MOUNTAIN VIEW ACADEMY
PRELIMINARY GRADING PLAN
GENERAL NOTES

# GEC Plan\_v1.pdf Markup Summary

MOUNTAIN VIEW ACADEMY
 PRE-DEVELOPMENT SITE GRADING
 AND EROSION CONTROL PLAN
 INITIAL GEC

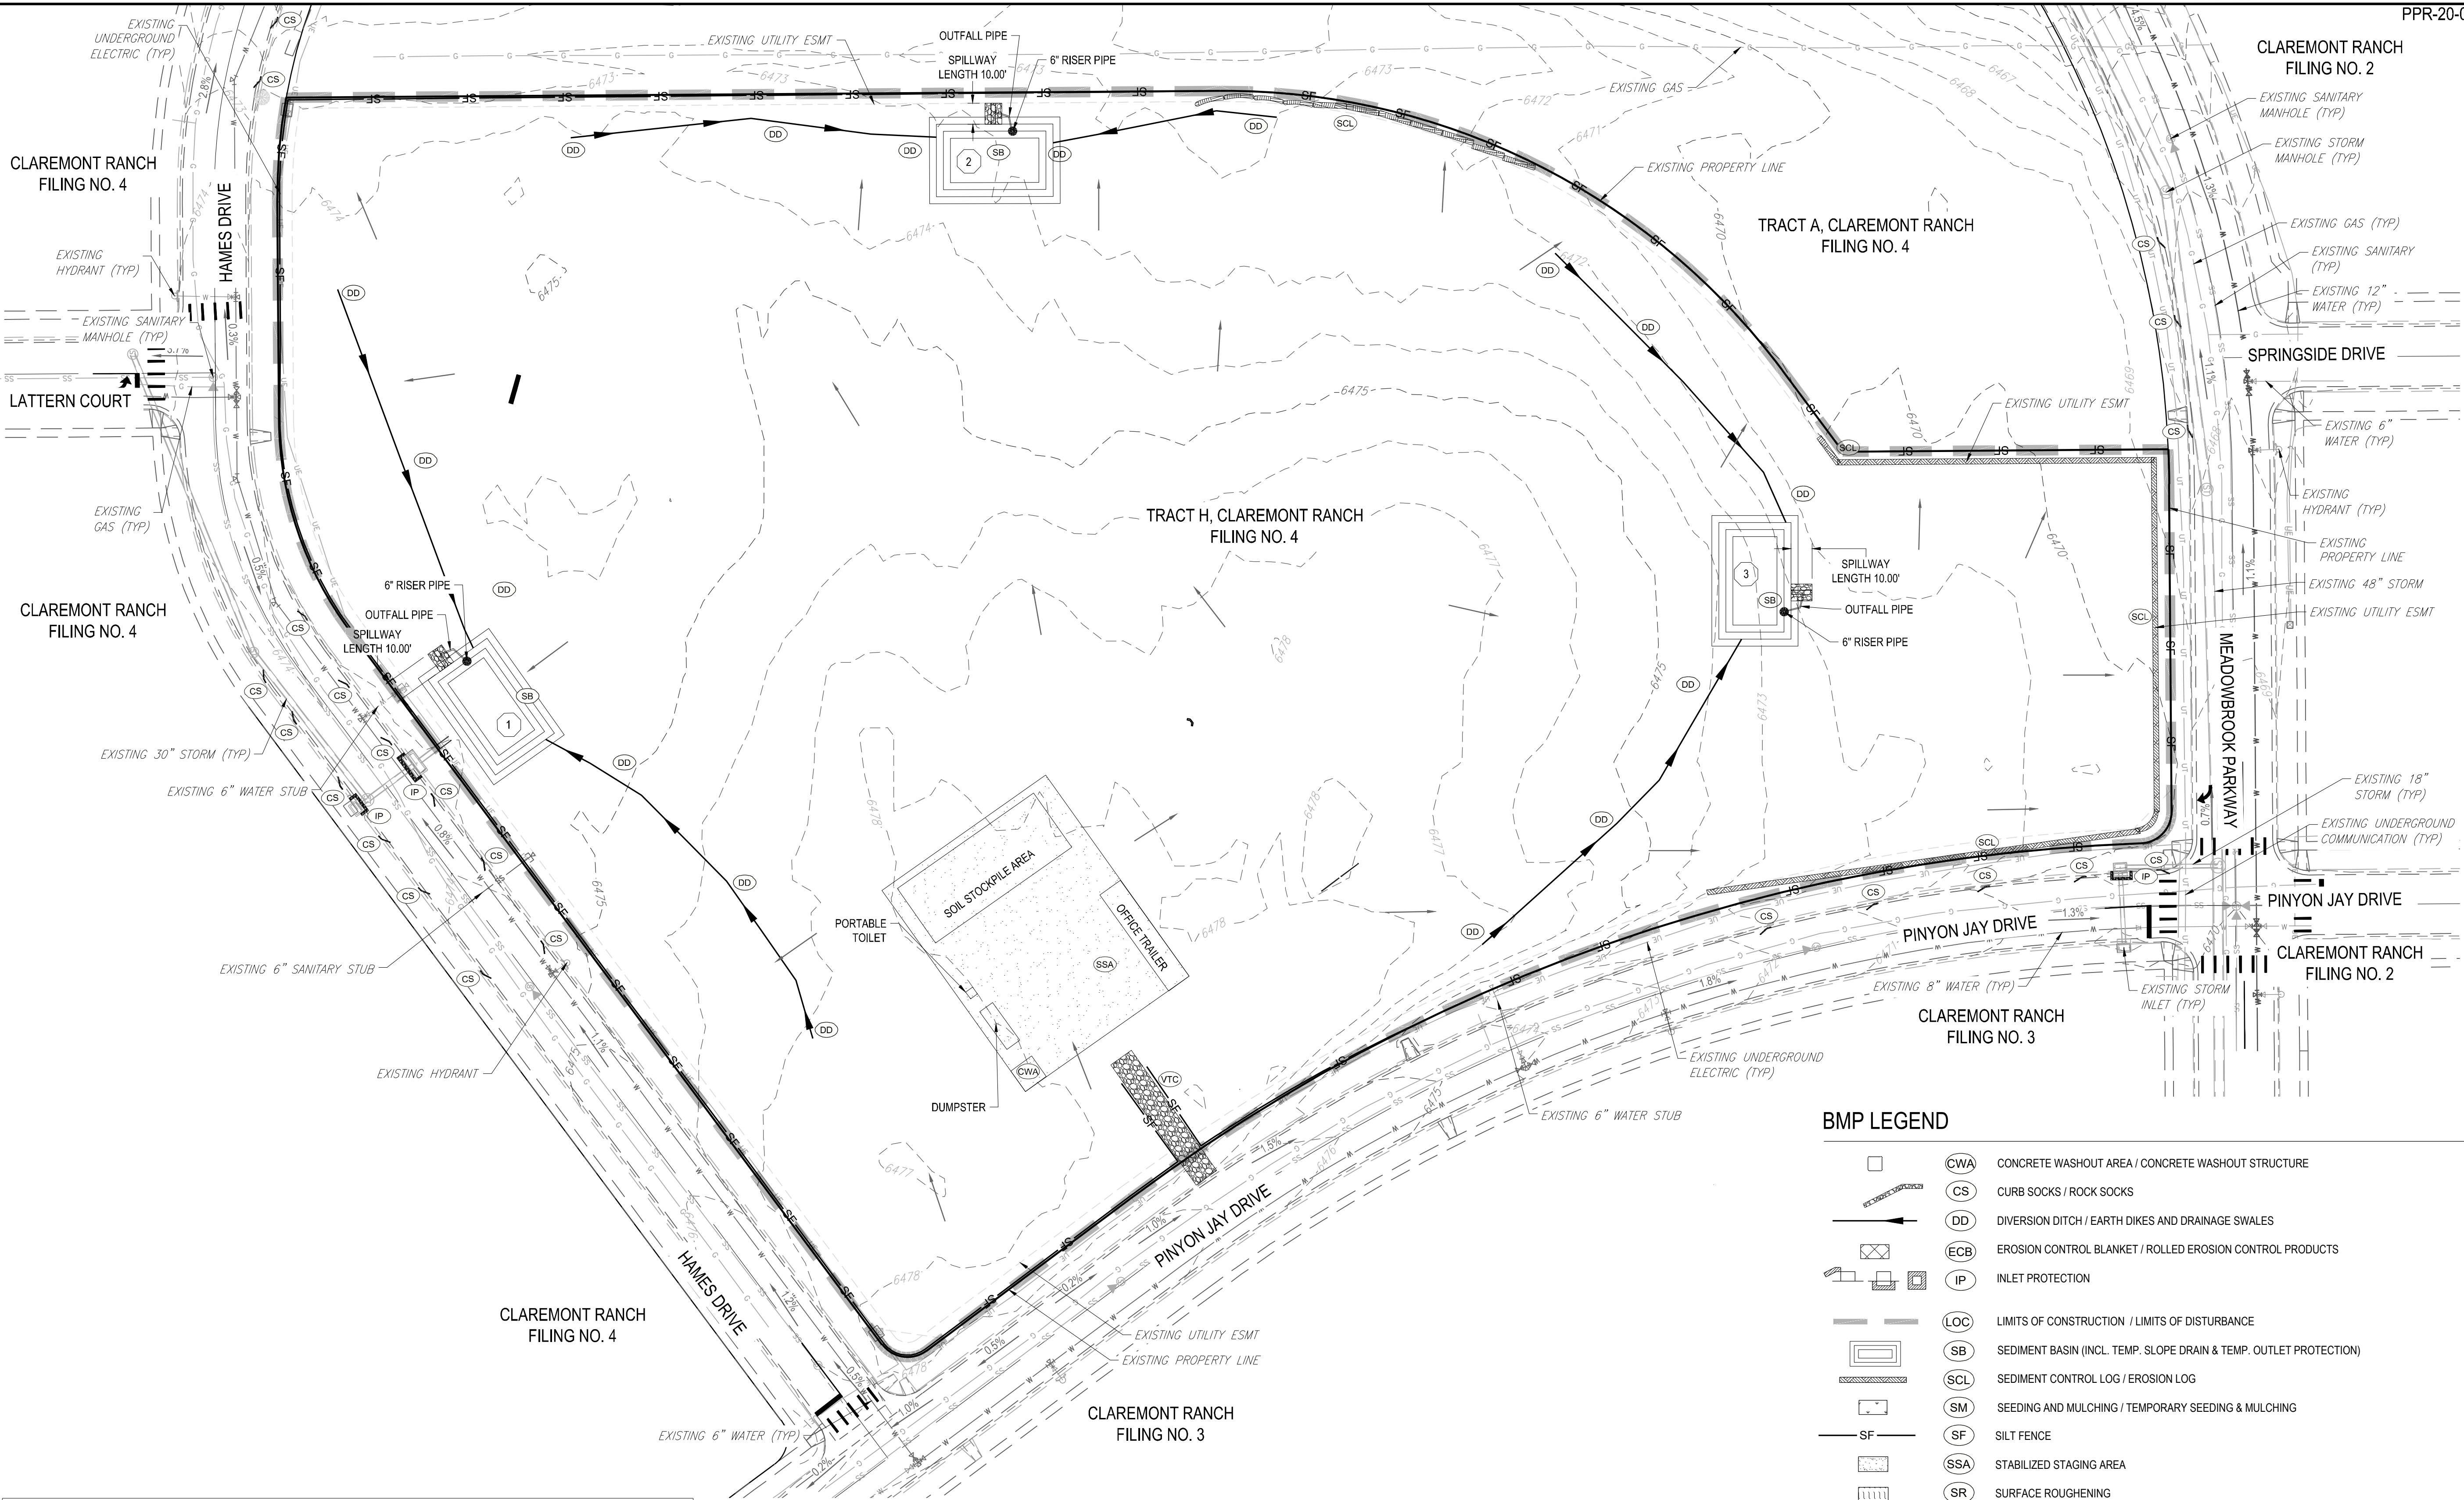
Identify as Initial GEC

Include temporary construction control measure details in the plan set.

Show the riser pipe, outfall pipe, and spillway locations.  
Identify the required perforation sizing, # of columns, spillway dimension, etc. (typ)

Demarcate the cut and fill areas. GEC checklist item 1p.

Update Legend to identify as both LOC and Limits of Disturbance if the delineation is the same for both.  
 GEC checklist item 1m.
